DARLING WALK FITOUT

ACCESSIBILITY REVIEW

Morris-Goding Accessibility Consulting

16th September 2009

Level 1

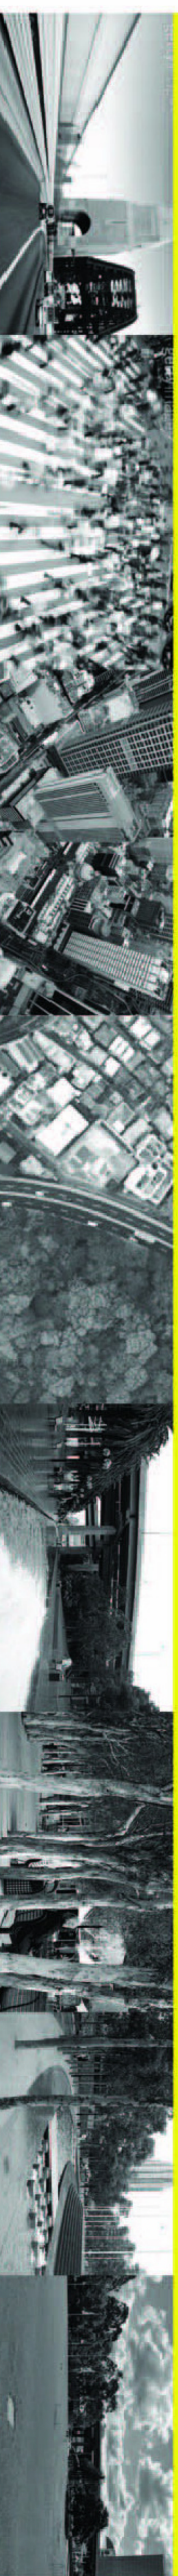
There is a dedicated first aid/parents room located at grid points C-5 on floor 01.

The corridor in front of this room has a 1000mm clear width, which will need modification.

The first aid/parents room has an 800mm clear widths, (870mm door leafs), compliant with AS1428.1.

- (i) Ensure the corridor is increased in width to achieve a 1200mm clear width, compliant with AS1428.1 fig 12.
- (ii) Ensure the first aid/parents room door is to have an 850mm clear widths (920mm door leafs), compliant with AS1428.2 & the City of Sydney DCP clause 4.2.6.

# Level 5

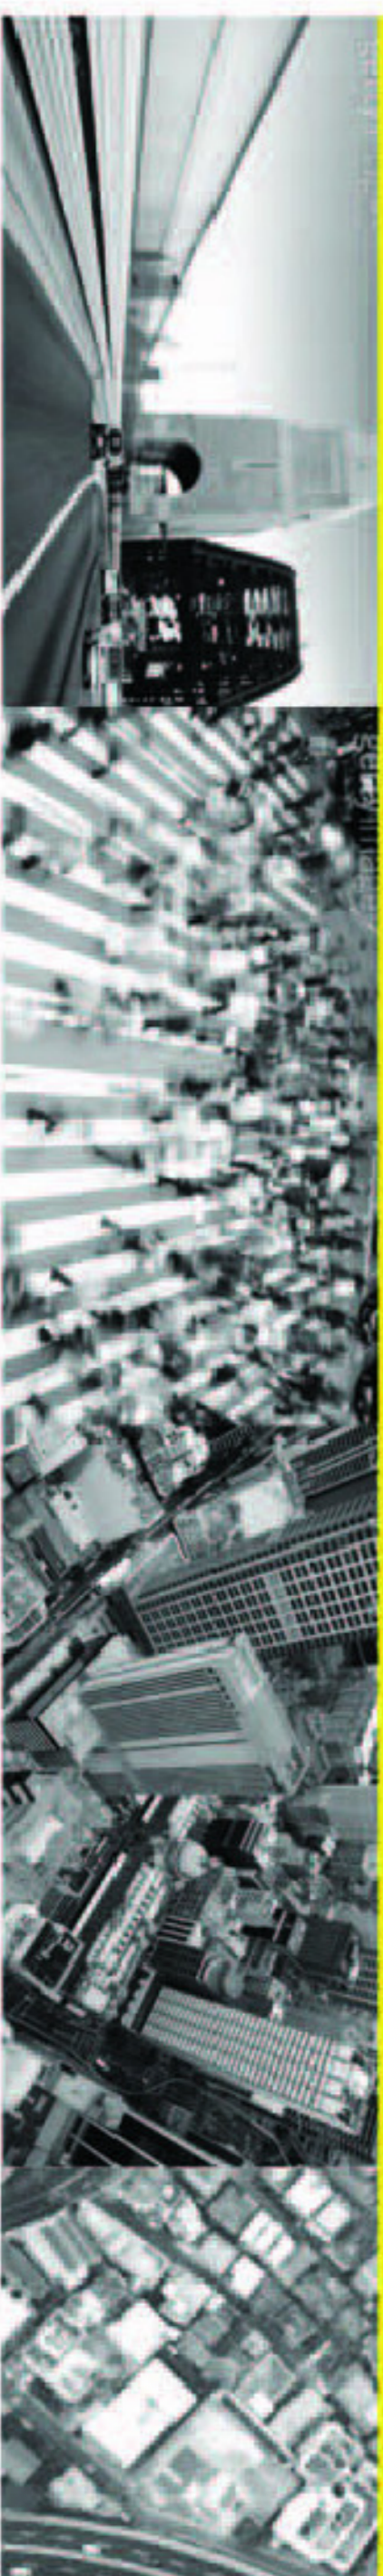
There is a balcony on floor 5 at grid points E-8. The circulation areas around the balcony will allow a person in a wheelchair to turn 180° in an equitable and dignified manner. The paths of travel around the balcony will allow two people in wheelchairs the ability to pass each other travelling in the opposite directions, compliant with AS1428.2.
